DEVELOPMENT FACILITATIVE TEAM (DFT)
Code Enforcement Comments

PR-2024-009800

PS-2024-00008 – SKETCH PLAT

REQUEST: Sketch Plat Review And Comment For A Proposed 2884 Square Foot Burger King Restaurant With A Drive- Through Window To Replace The Former 3606 Square Foot Gas Station And Auto Service Shop.

ENGINEER'S SEAL	PORTION OF TRACT A SHOPCENTER ORD1857	DRAWN BY DEM
	2901 EUBANK BLVD. NE	DATE 11-9-24
	GRADING AND DRAINAGE PLAN	Burge King - Estab & Corbett, Inc.
		SHEET # C1
11/13/24		JOB #

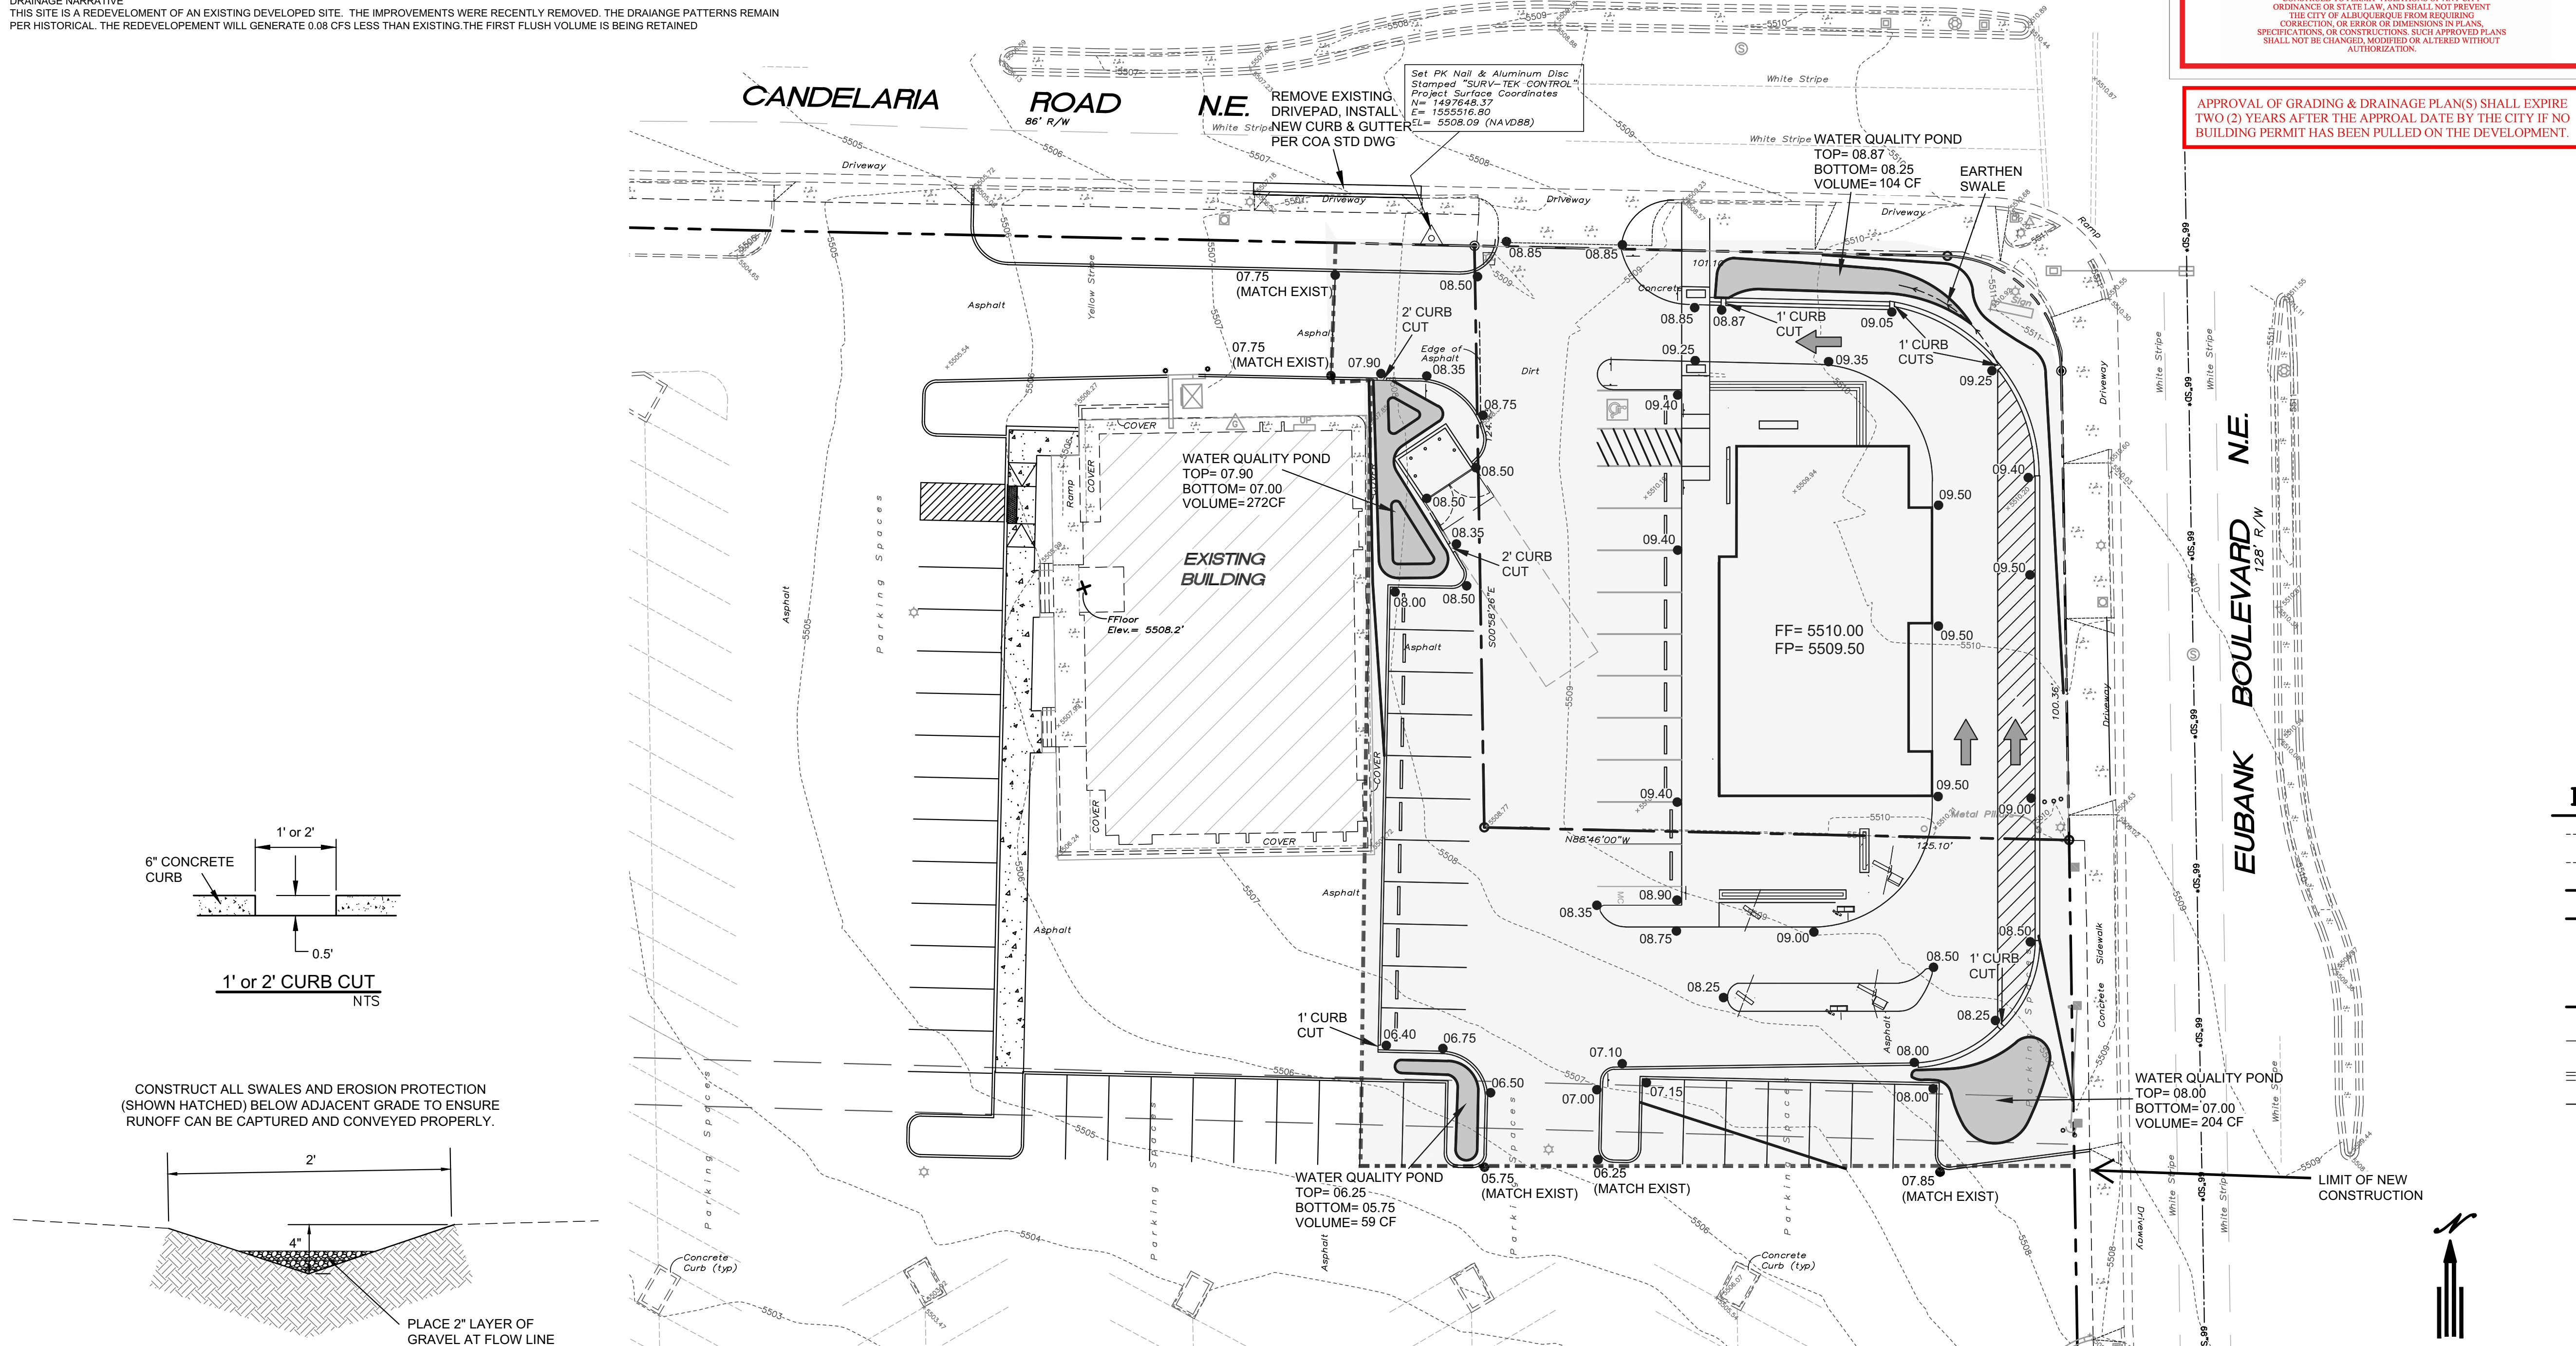
- Hydrology needs to approve a Conceptual Grading & Drainage Plan prior to Site Plan for Building Permit.
- Comment – Prior to submitting for Building Permit, a licensed New Mexico civil engineer will need to submit a Grading & Drainage Plan to Hydrology for review & approval if one of these conditions is met. (500 cy of grading, 1,000 sf of proposed building, or 10,000 sf of proposed paving).

A A1.1 TRAFFIC CONTROL LAYOUT
1" = 20'-0"

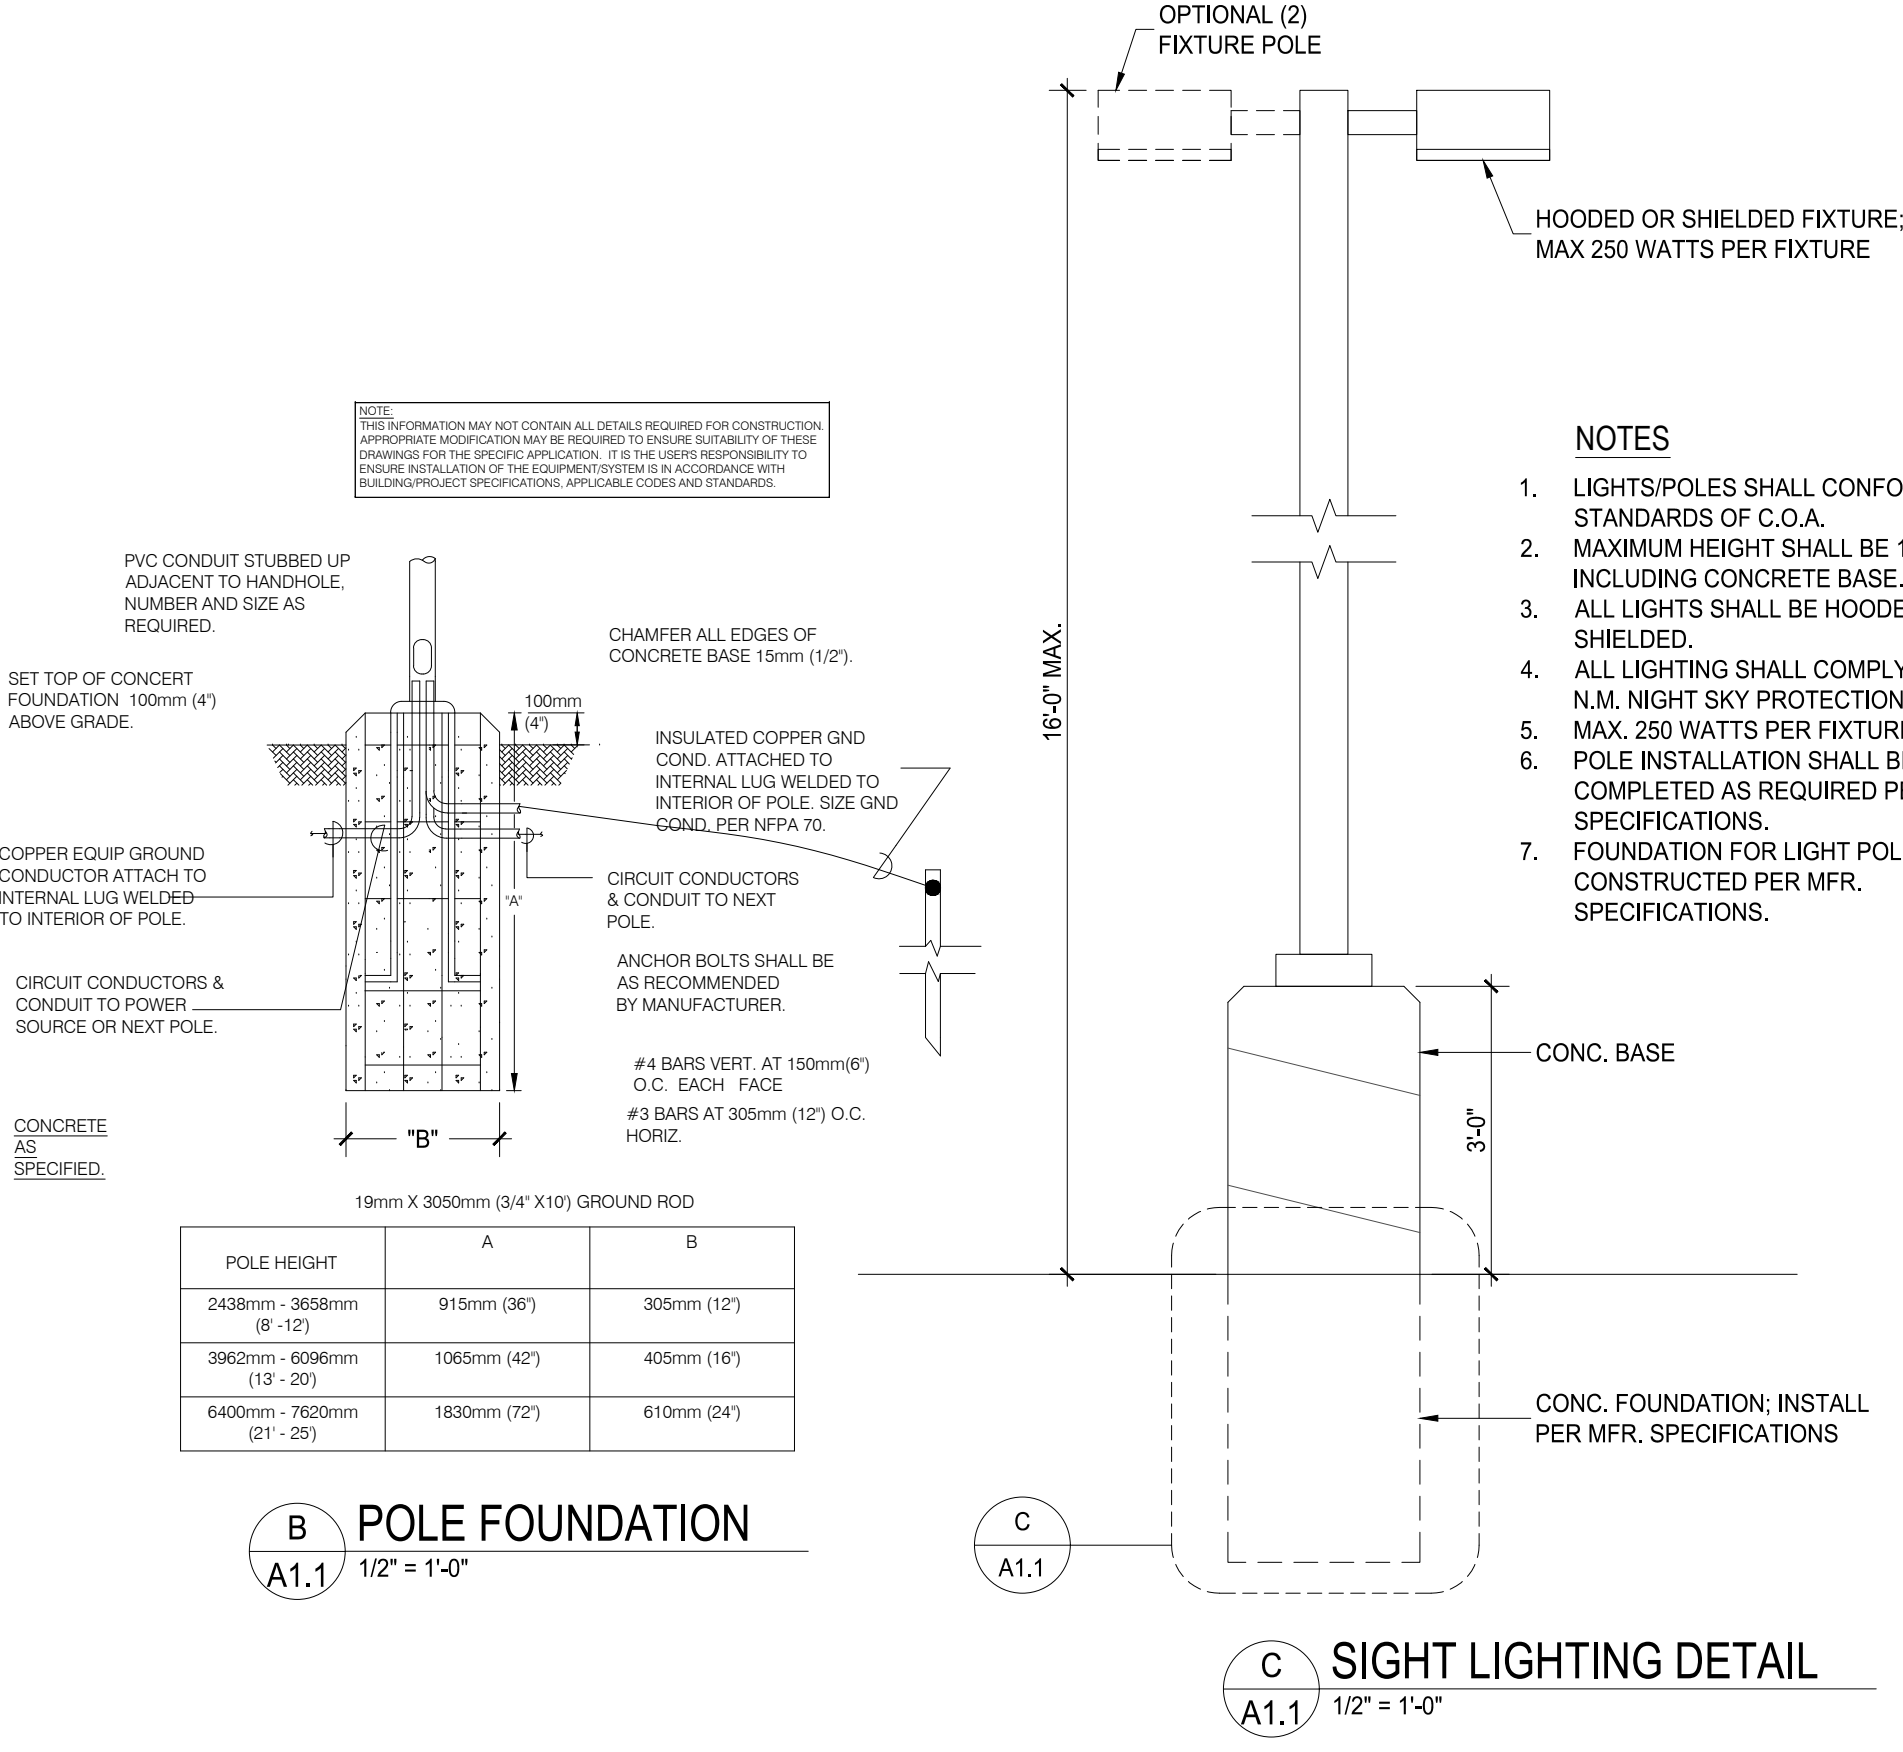
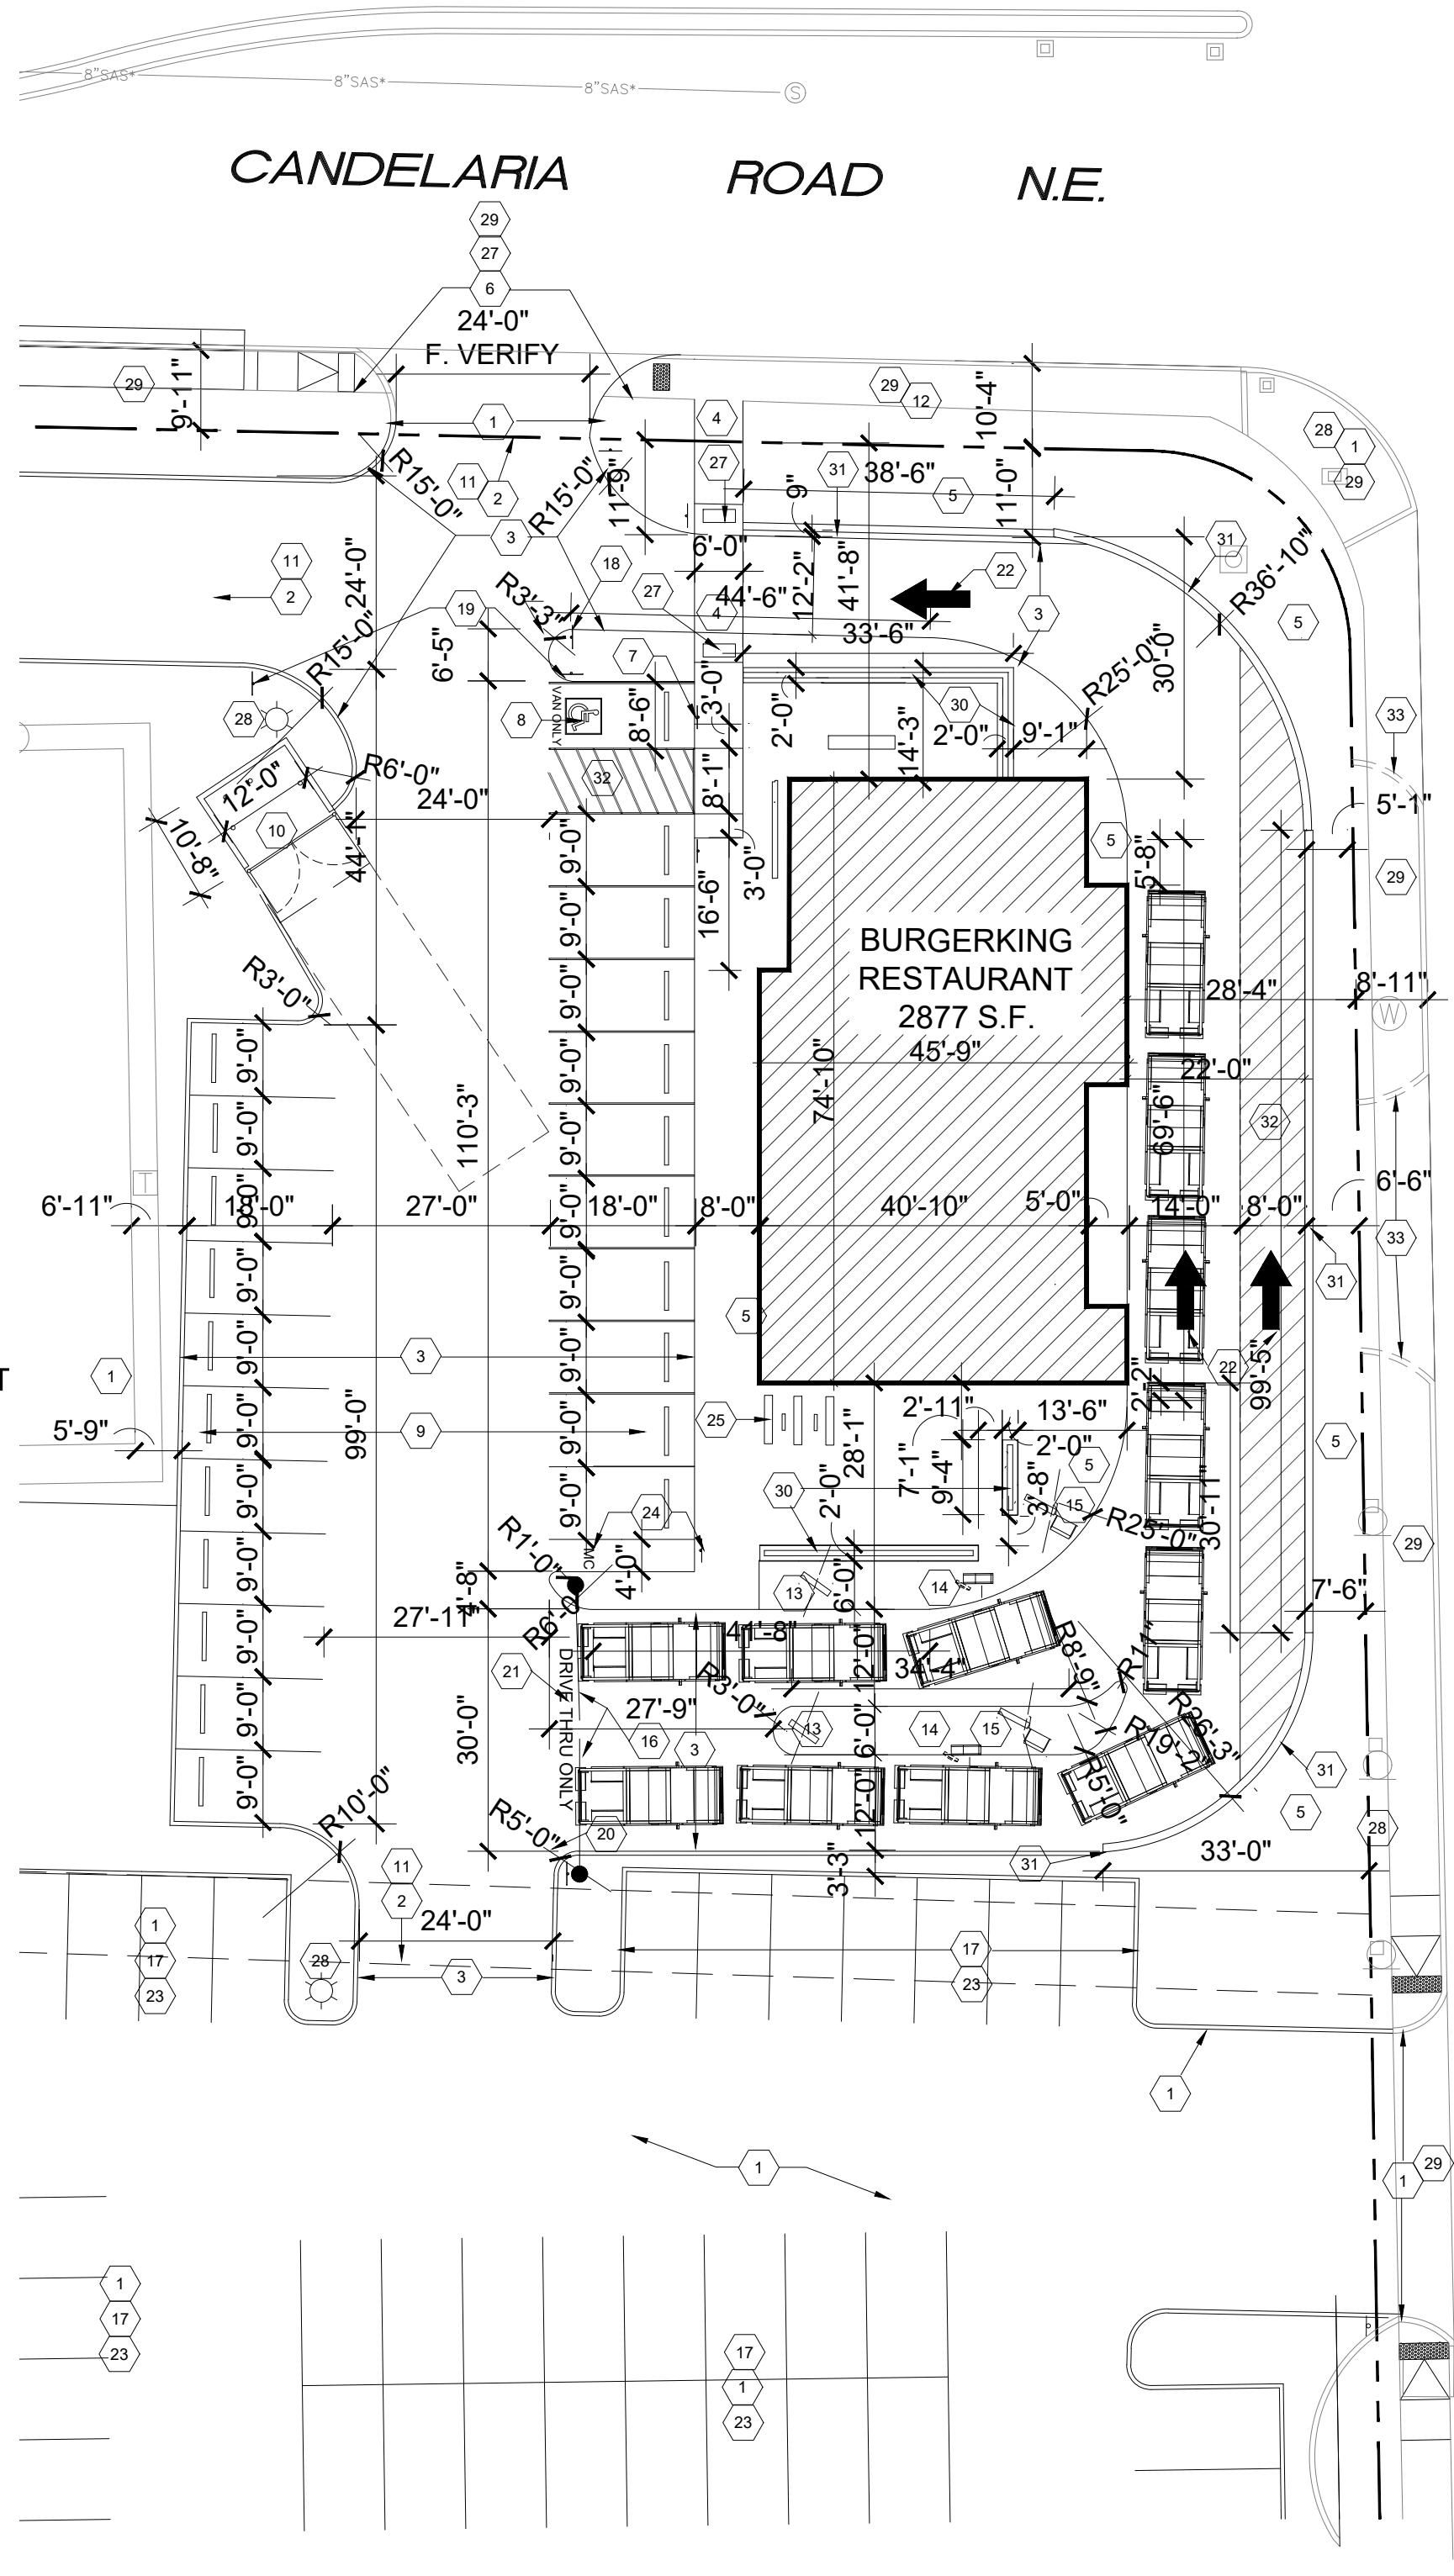
1. Property is zoned MX-M and is located within an approved Shopping Center site plan, #1002623. Must obtain amendment of existing site plan.
2. Must provide screening of Drive-through lane adjacent to right-of-way along both Eubank and Candelaria, as per IDO 5-5(I)(2)(a). Submittal shows partial screening, but only of the curved area of the drive-through lane. Must provide either continuance of a wall and/or a vegetative screen of sufficient height and density.
3. Landscaping must meet requirements of IDO 5-6 and/or as stipulated by amended Site Plan.
4. All signage must meet standards of IDO 5-12 and/or as stipulated by amended Site Plan.
5. Code Enforcement has no further comments at this time.

1. Eubank is a Principal Arterial and requires a 6' sidewalk with a 5' – 6' landscape buffer. Candelaria is a Minor Arterial and requires a 6' sidewalk with a 5' – 6' landscape buffer. Please list sidewalk and buffer width. If these widths do not meet requirements ROW dedication may be required.
2. An approved TCL is required prior to site plan approval or building permit. Please fill out and submit a Traffic Scoping Form to Matt Grush (mgrush@cabq.gov) to determine if a TIS will be required. If needed, the TIS will need to be approved prior to site plan or building permit.

- ***Demonstrate compliance with section 7 of the DPM Table 7.2.29 regarding Sidewalk width requirements and its landscape buffer.**
 Verification of DPM standards per Transportation
 Eubank is a Principal Arterial and requires a 6' sidewalk with a 5' – 6' landscape buffer.
 Candelaria is a Minor Arterial and requires a 6' sidewalk with a 5' – 6' landscape buffer.
